Re: Gwandalan Residential Subdivision Project Application MP 10-0205

I wish to object to the above proposed subdivision for the following reasons:

Longitudinal Section - Kanangra Drive (MC00)			
Council:	Wyong	Projection:	M.G.A.
Datum:	A.H.D.	North Direction:	Grid
Source:	ADW Survey	Plan By:	MJH
Contour Interval:	N/A	Checklist:	MJH

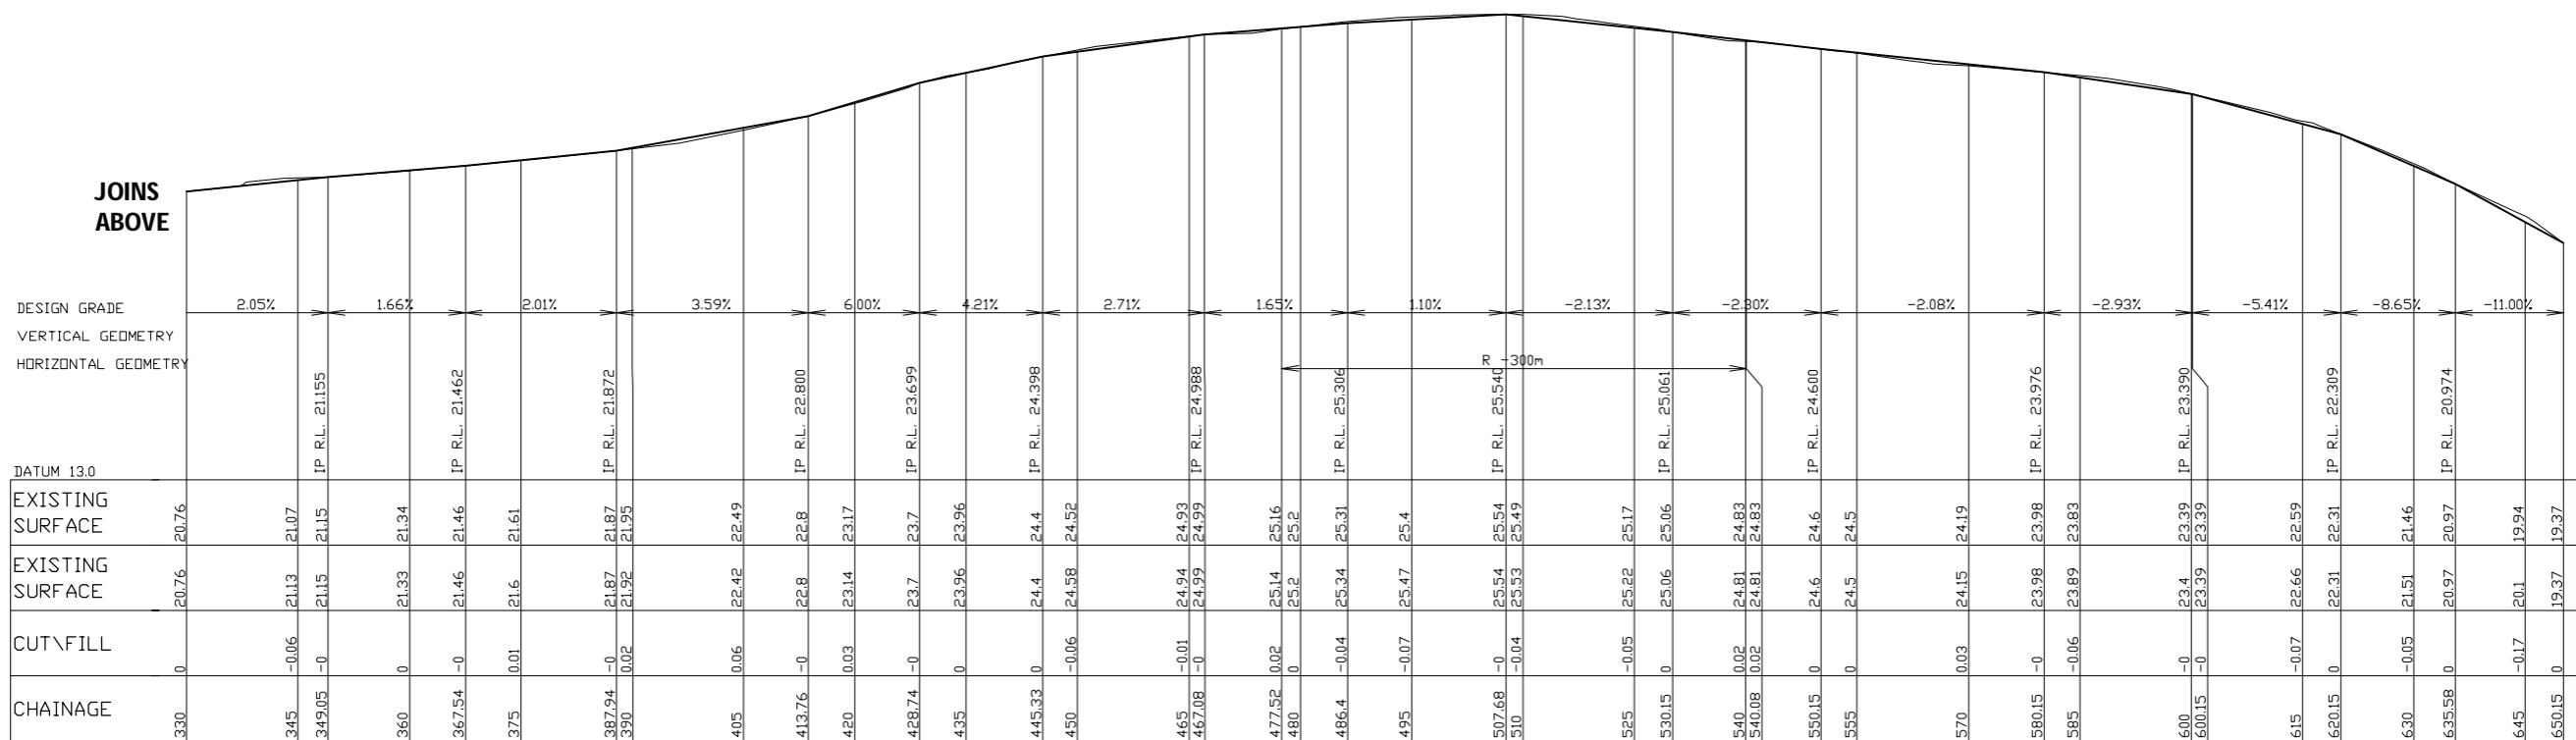
- There doesn't seem to be any commitment to upgrade Kanangra Drive adjacent to the proposed estate. This road carries minimal traffic to the Point Wolstoncroft camp, but is heavily parked by parents accessing the Gwandalan public school. Upgrading needs to be done to make this road safer for all users in event of more residents. Wyong Council requires that the developer

provides a minimum sealed pavement 9 metres in width to be curbed and guttered. In addition, the intersection between Kanangra Drive and Orana Road needs upgrading.

Stormwater Catchments			
Council:	Wyong	Projection:	M.G.A.
Datum:	A.H.D.	North Direction:	Grid
Source:	ADW Survey	Plan By:	MJH
Contour Interval:	1.0m (Des & Nat)	Checklist:	MJH

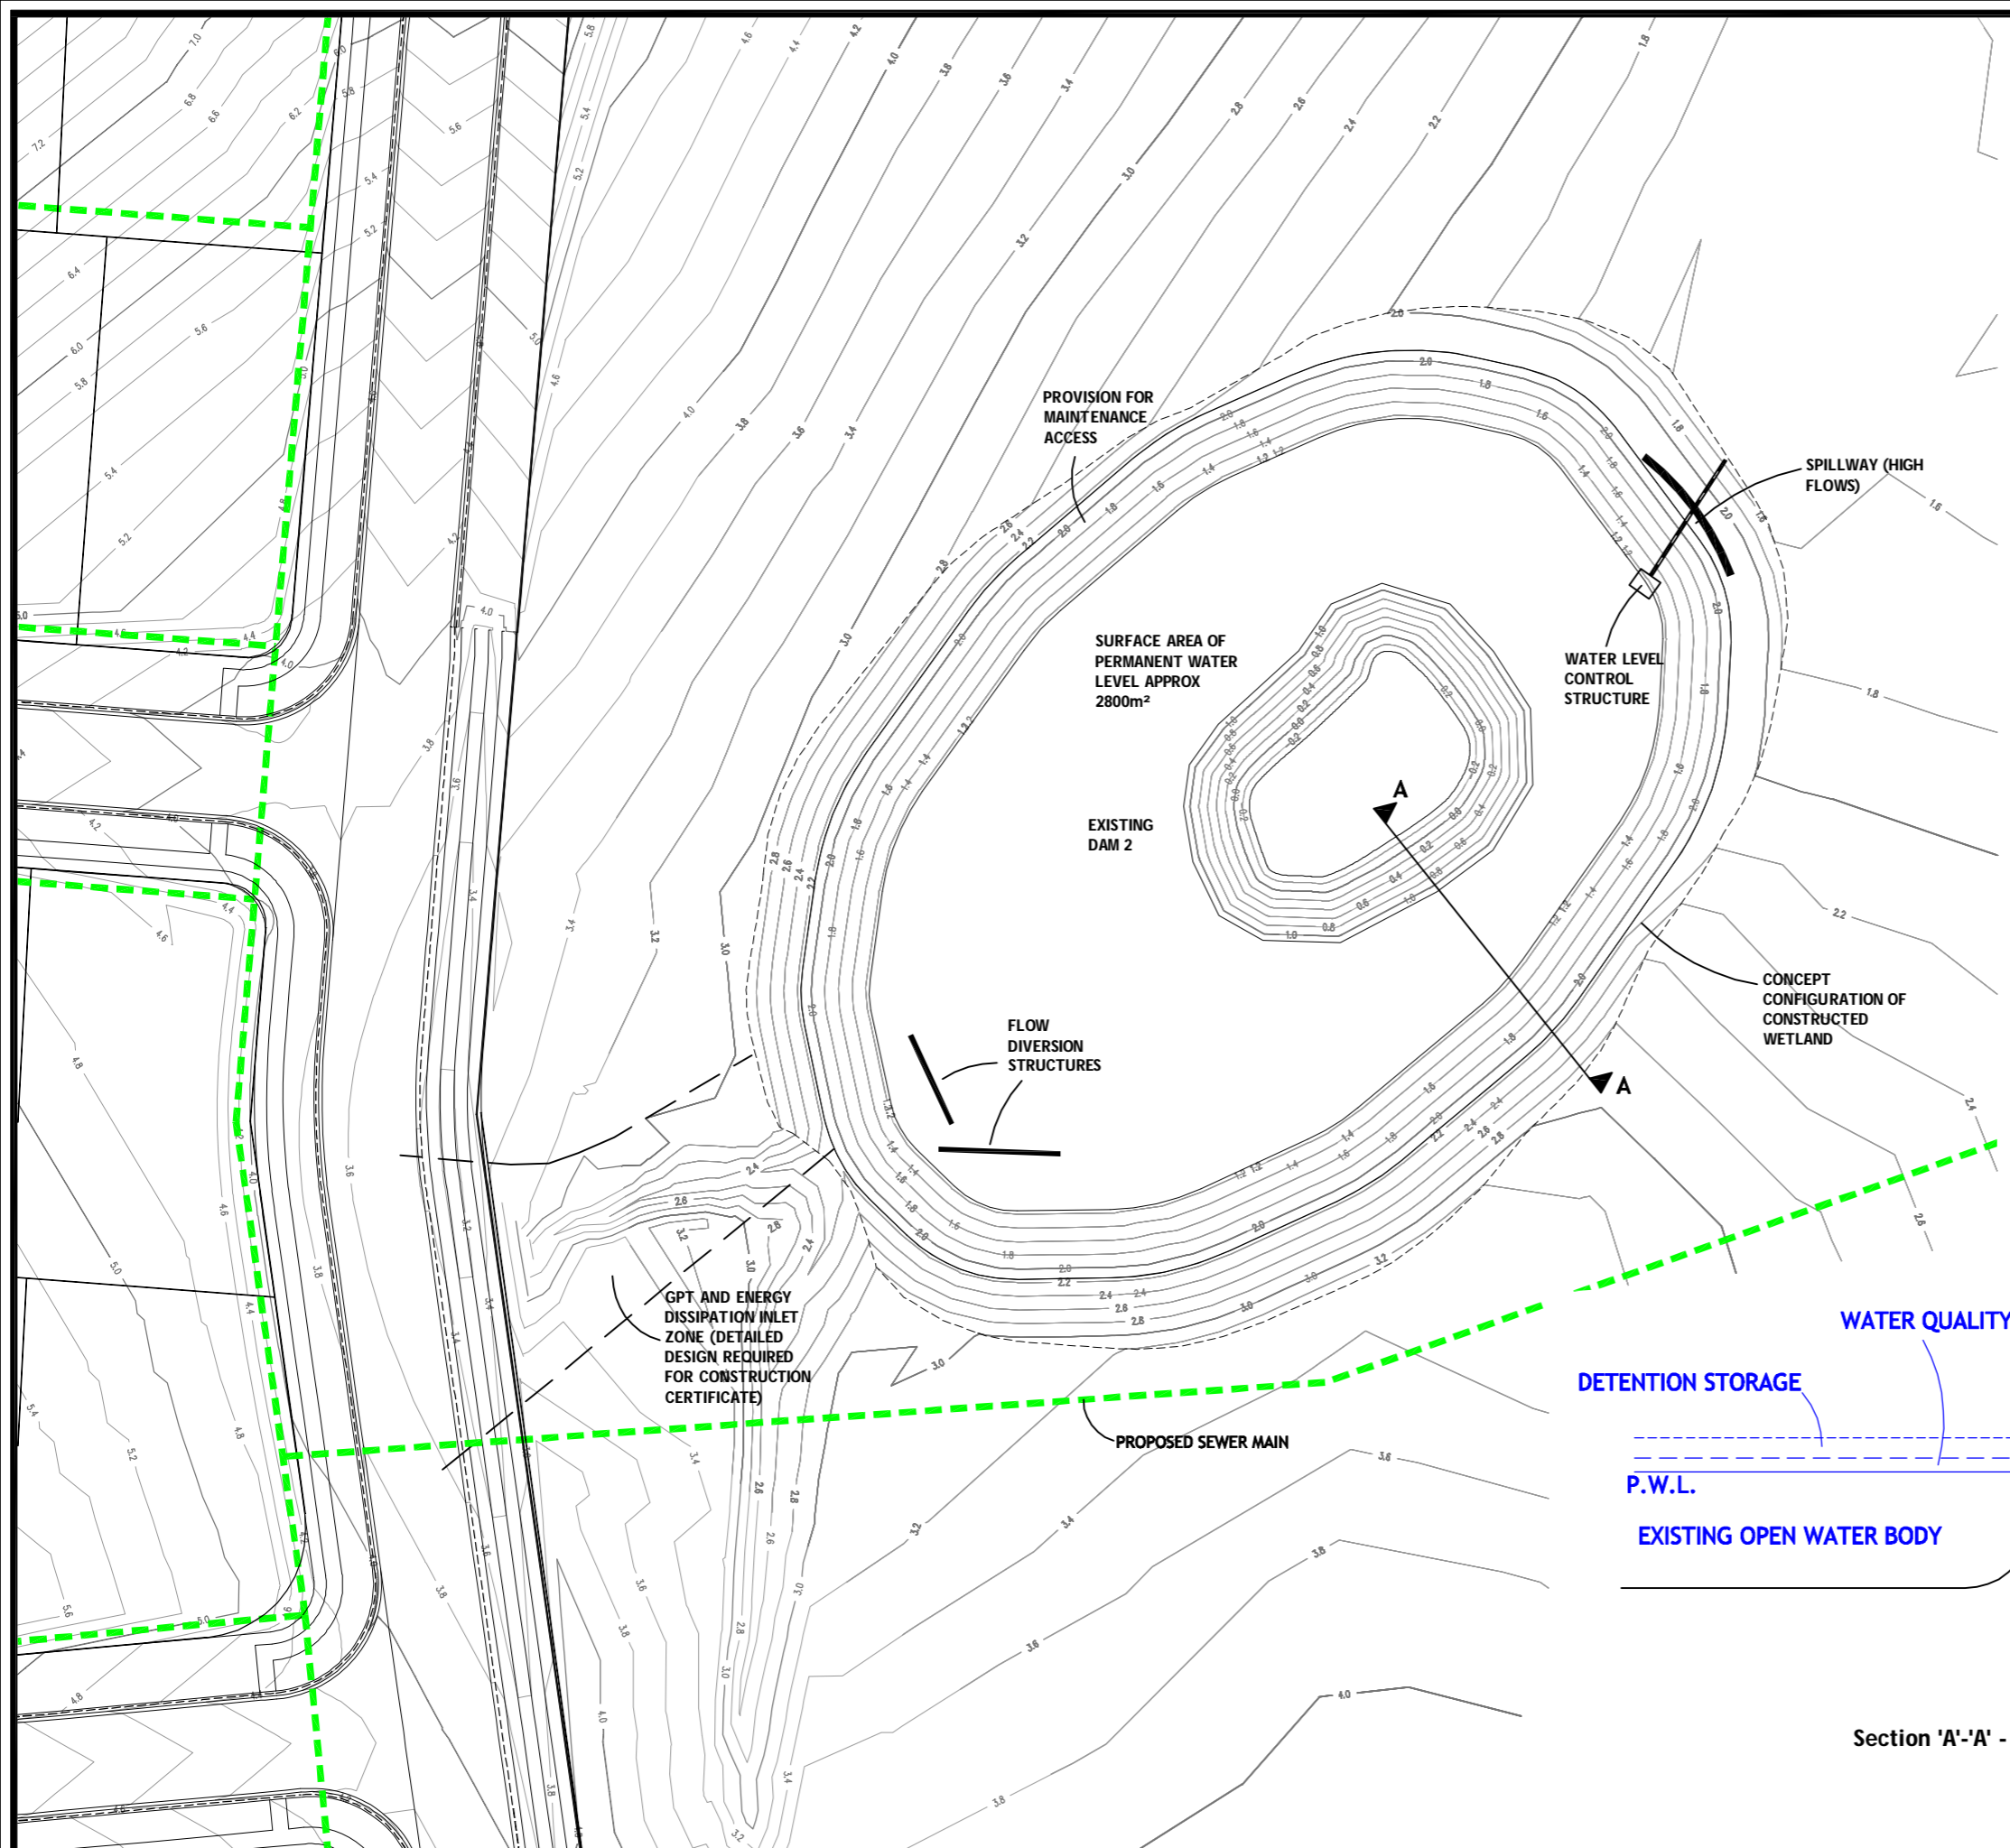
- Stormwater controls for the subdivision are to be located on the residue lot which is Zoned 7b Environmental protection. While this land is currently owned by the developer, over time this may change. Who will maintain this wetland since it is on private land?
